DECISION DELEGATED TO DEVELOPMENT MANAGER
--

Application No:	H23-1024-20	Applicant:	Mr & Mrs Bray
Proposal:	Proposed Dwelling and Garage		
Location:	Adj. Maryland Oxcroft Bank Shepeau Stow		
Terminal Date:	20th January 2021

Full planning permission is sought for a 4 bedroom house and detached double garage.

Job Title Proposed Dwelling Maryland, Oxcroft Bank, Shepeau Stow, Whaplode Drove, PE120TY For: Mr and Mrs Bray	Date October 2020	Drawn by SHe
	Checked by JB	
Drawing Title Planning Drawing Elevations & Floor Plans	Job No. SE-1433	Sheet Size A1
	Dwg No. PP1100	Revision

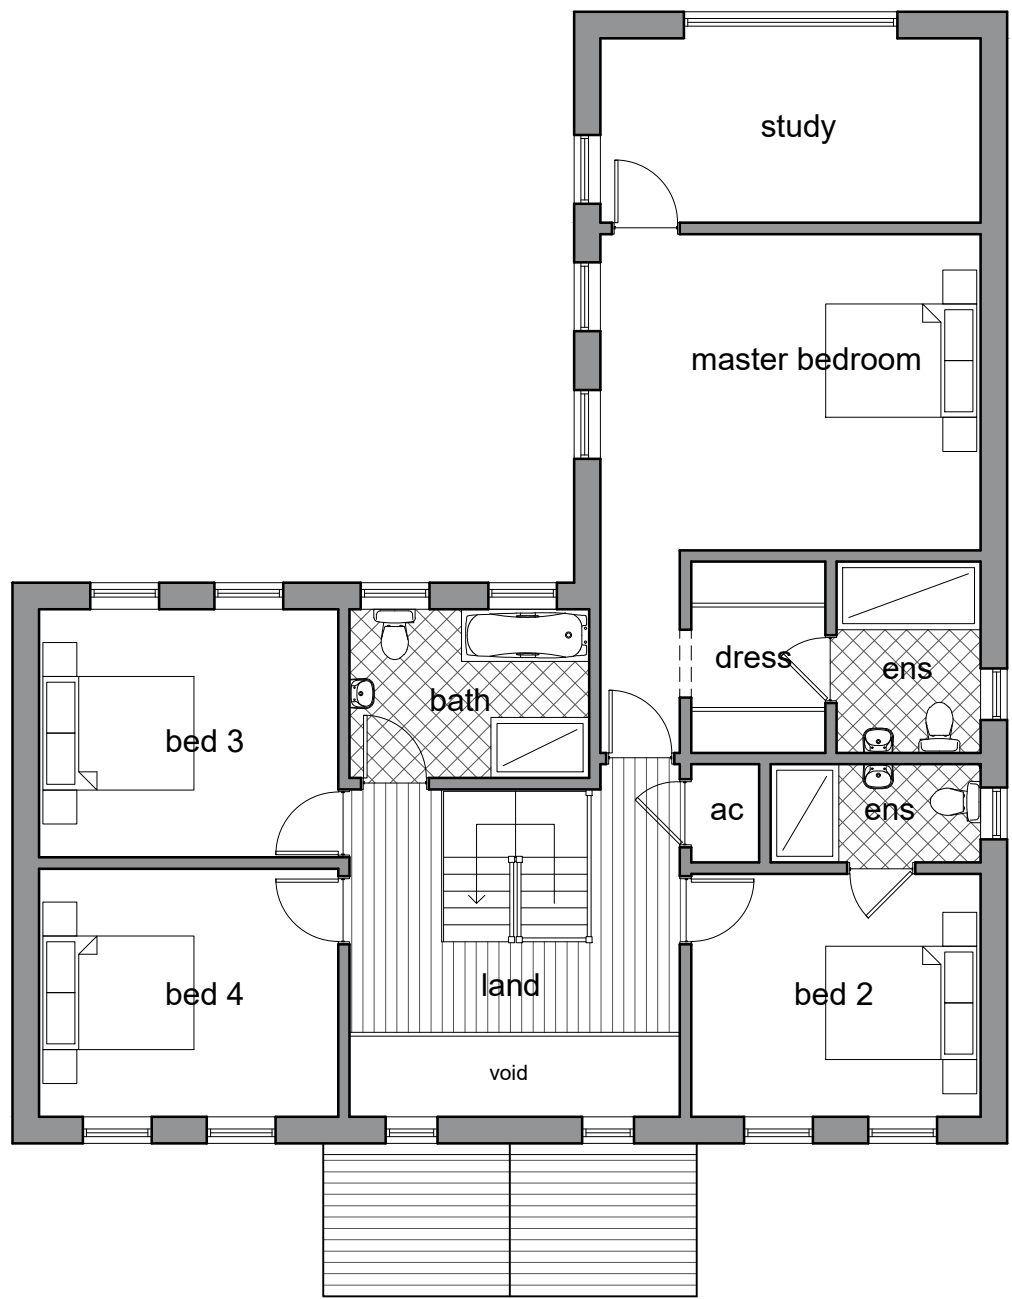
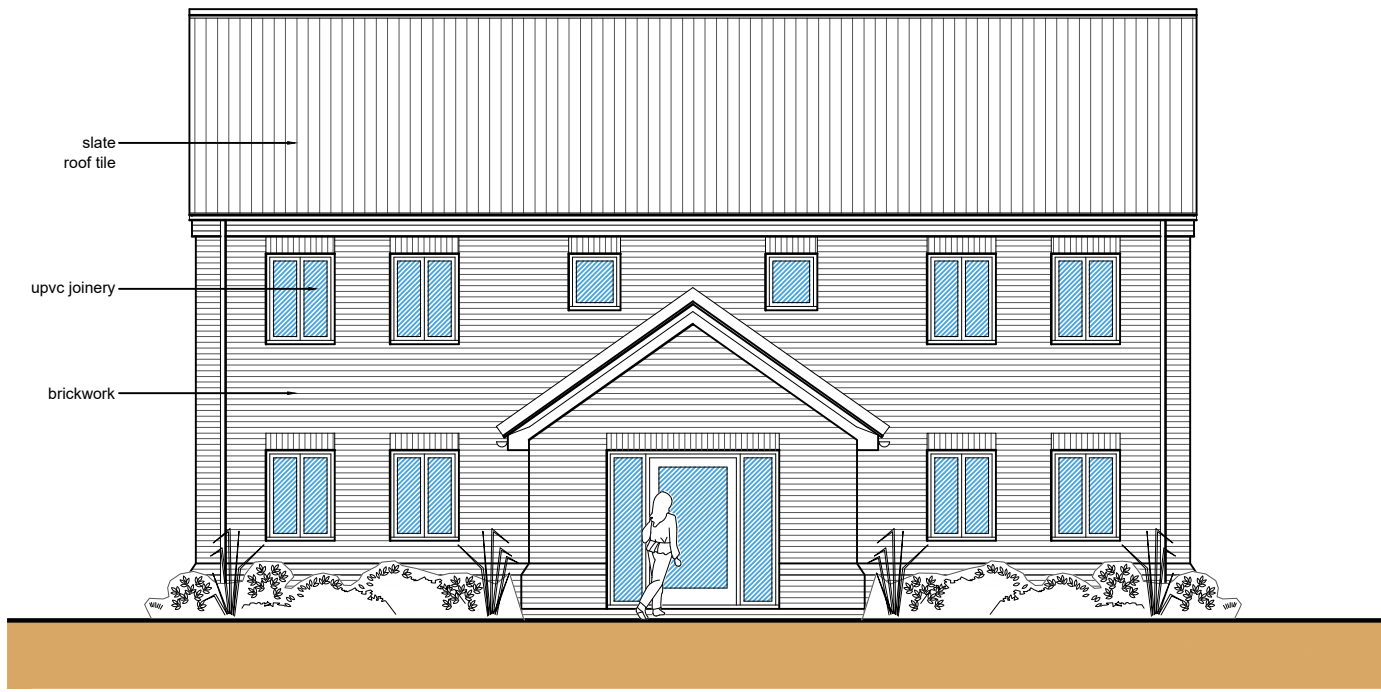
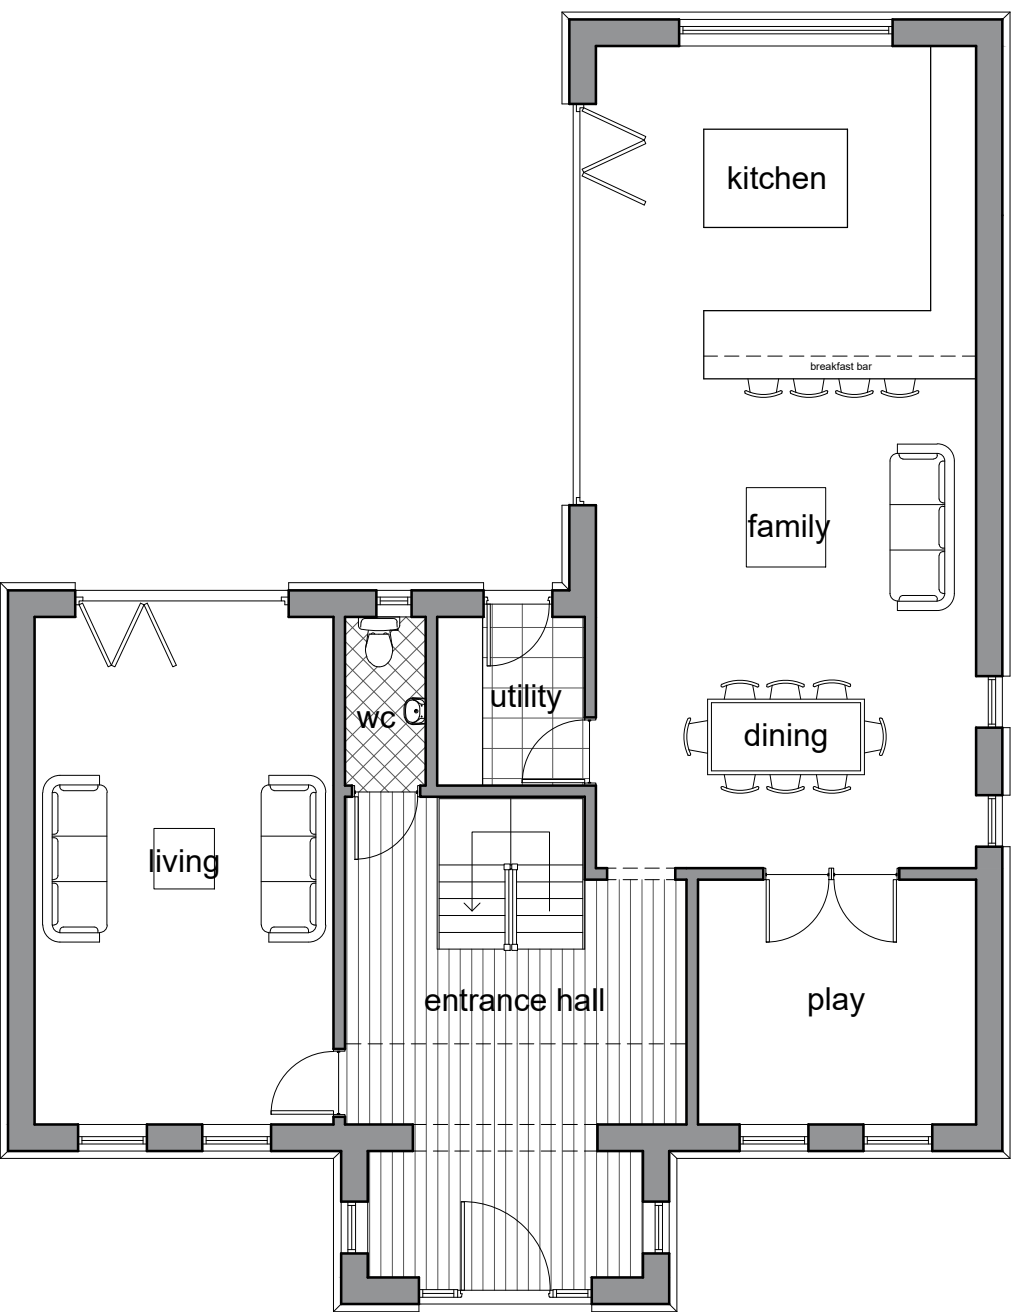
In terms of overlooking, the front of the proposed dwelling is forward of the rear elevation of Marilyn. On its north-eastern elevation it only has narrow dining room windows on the ground floor and ensuite windows at first floor level. The rear section of the north-eastern boundary from the centre of Marilyn backwards is de-lined by a 1.8 metre high closeboarded fence.

Concerning possible overshadowing/blockage of light, Marilyn to the north-east has kitchen and dining/sun room windows on the rear section of its side elevation facing the site and a window on the rear elevation serving the latter. It also has two dormers on the side elevation serving a bedroom. However, the proposed dwelling is only 2.5 metres further forward than the rear of Marilyn and some 6.3 metres from its side wall. Although there would be some blockage of sunlight later in the day during winter months and later evening in the summer the extent is not considered to be such as to justify refusal. Moreover, occupiers of the neighbouring dwelling have not objected to the scheme.

Job Title		Date	Drawn by
Proposed Dwelling		October 2020	ShE
Maryland, Oxcroft Bank, Shepeau Stow, Whaplode Drove, PE120TY			Checked by
For: Mr and Mrs Bray			JB
Drawing Title		Job No.	Sheet Size
Planning Drawing		SE-1433	A1
Site Plan, Location Plan & Garage Plans		Dwg No.	Revision
		PP1000	A

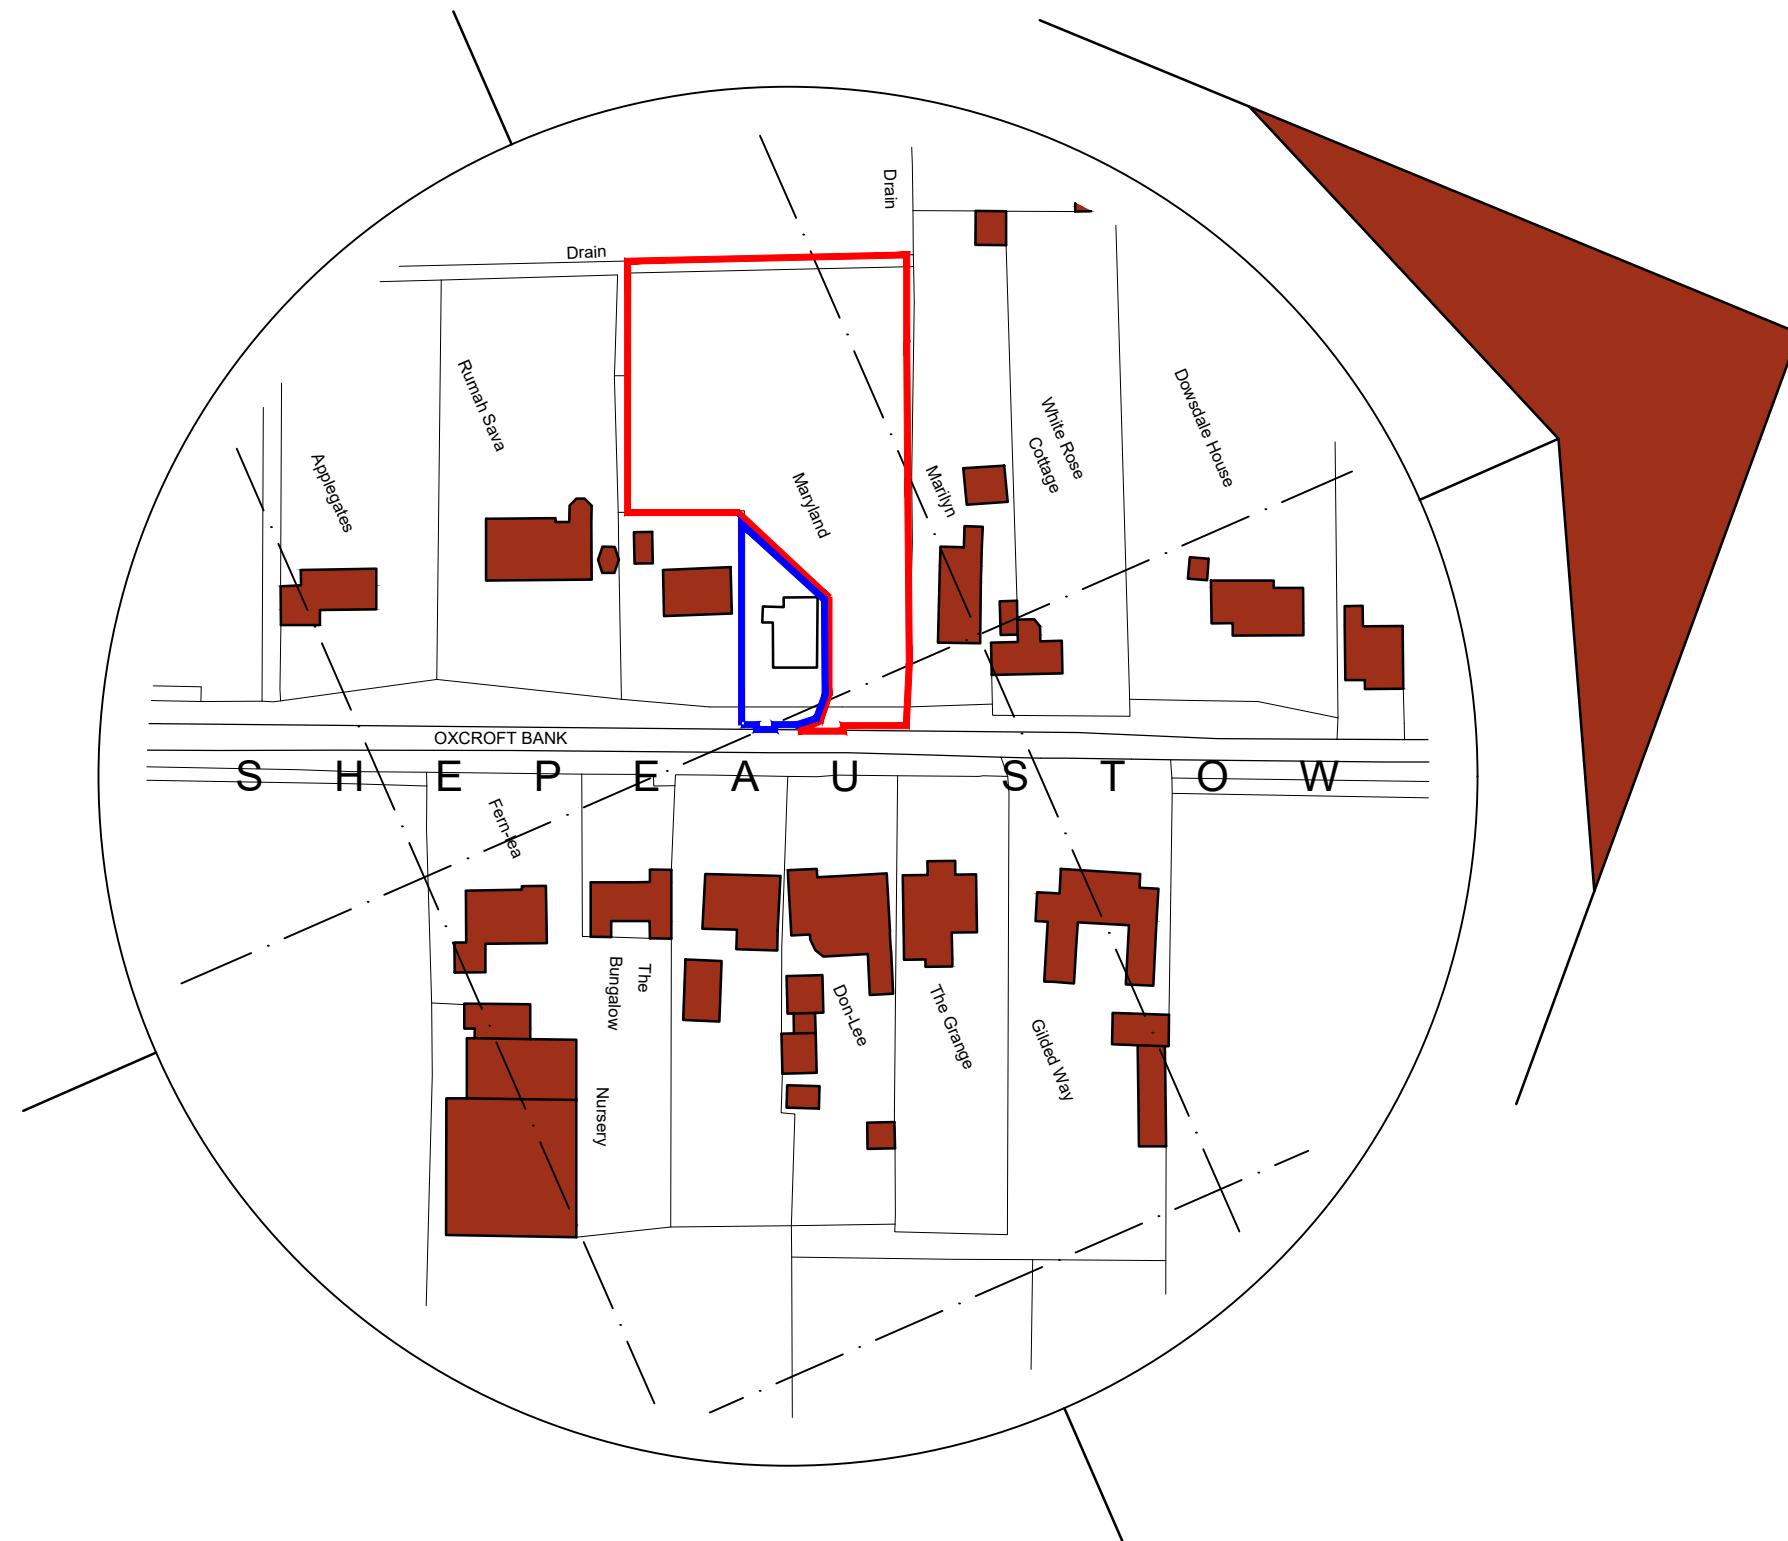
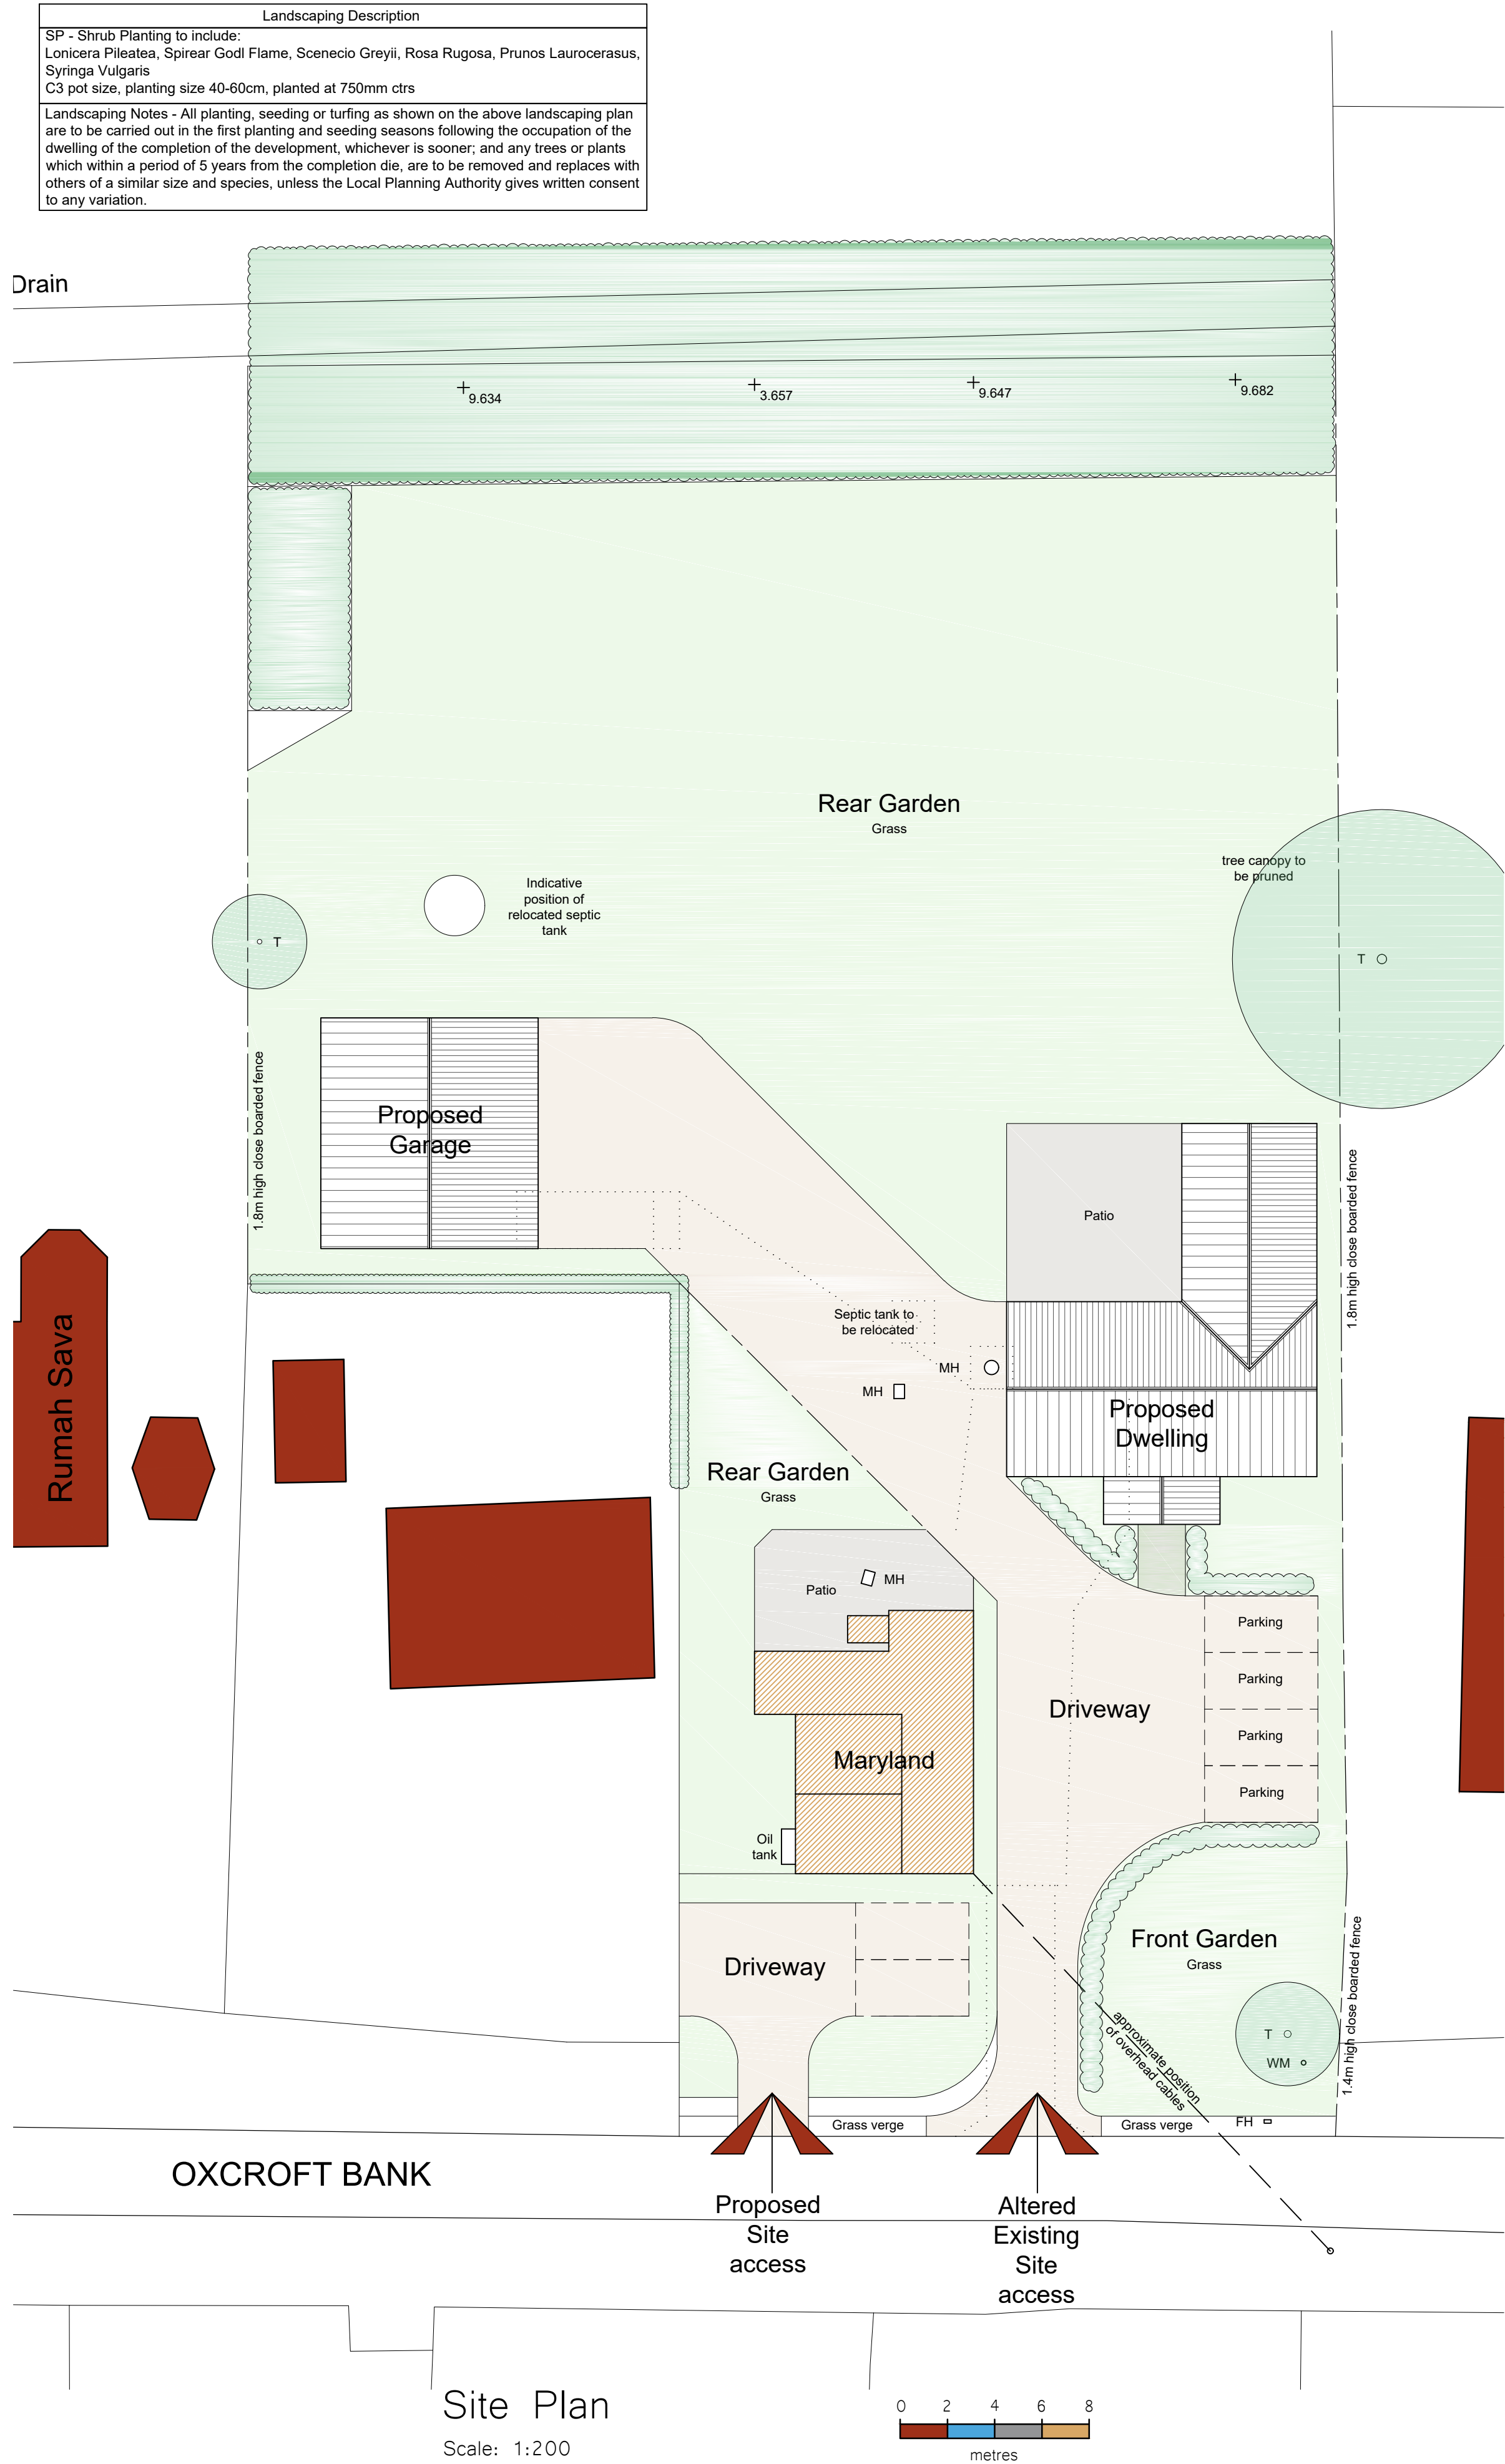
The proposed house would be set further back than the neighbouring properties. However, it would be on a similar building line as Rumah Sava to the south and is of similar scale and design to other larger properties along this part of Oxcroft Bank. It is considered, on balance, that it would not materially harm the character or appearance of the rural locality.

The proposed dwelling utilises an existing access and a new access would be formed to serve Maryland. Concerns have been raised on grounds that Oxcroft Bank is unsuitable for additional development and has no footway, street lighting, etc. However, the proposal is only for a single dwelling, with four parking spaces, and the access is onto a straight road with satisfactory visibility. LCC Highways has raised no objections on highway safety grounds. The proposal therefore satisfactorily complies with Policies 2, 3 and 36 of the SELLP.

Foul water would be disposed of via a septic tank and surface water via soakaways. The site is large enough to accommodate such facilities, including any associated drainage fields if required.
